**City of Albuquerque Stormwater Construction Site Inspection Report**

ESC File No.	D09E006	Project Name:	Twilight at Quivera Estates		
NPDES Id. No.	NMIR1004BU	Location:	6700 Quivera Dr. NW		
9/10/2025	Owner	Contractor			
Operator	Quivera Land, LLC	Twilight Homes			
Contact name & title	Tim McNaney	Tim McNaney			
e-mail	<a href="mailto:tmcnaney@twilighthomes.com">tmcnaney@twilighthomes.com</a>	<a href="mailto:tmcnaney@twilighthomes.com">tmcnaney@twilighthomes.com</a>			
Contact Phone #	322-6027	322-6027			
<b>COA Inspector</b>	<b>Chancellor English</b>		9am		
Construction Phase:	verticals, several houses complete				
Type of Inspection:	<input checked="" type="checkbox"/> Regular	<input checked="" type="checkbox"/> Storm Event	<input type="checkbox"/> Post Storm Event >0.25"	<input type="checkbox"/> 311/Complaint	<input type="checkbox"/> Follow Up
Weather at time of inspection?	clear		Temperature: ~	80	
9/10/2025

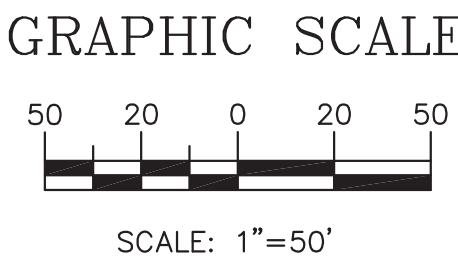
Item Number	Deficiency/ Corrective Action				
1	The SWPPP Map needs to be brought up-to-date to reflect the transfer of properties to Abrazo Homes and Twilight Homes per CGP Part 7.4.1. The 2017 CGP needs to be replaced by the 2022 CGP in the SWPPP in violation of CGP Part 7.2.11. The most current inspection report was dated over a month ago in violation of CGP Part 4.7.3. Required mitigation: You must modify your SWPPP, including the site map(s) to reflect areas on your site map where operational control has been transferred (and the date of transfer) since initiating permit coverage per CGP Part 7.4.1.b. You must include a copy of the 2022 Construction General Permit in the SWPPP per CGP Part 7.2.11. You must keep a copy of all inspection reports at the site or at an easily accessible location so that they can be made immediately available at the time of an on-site inspection per CGP Part 4.7.3.
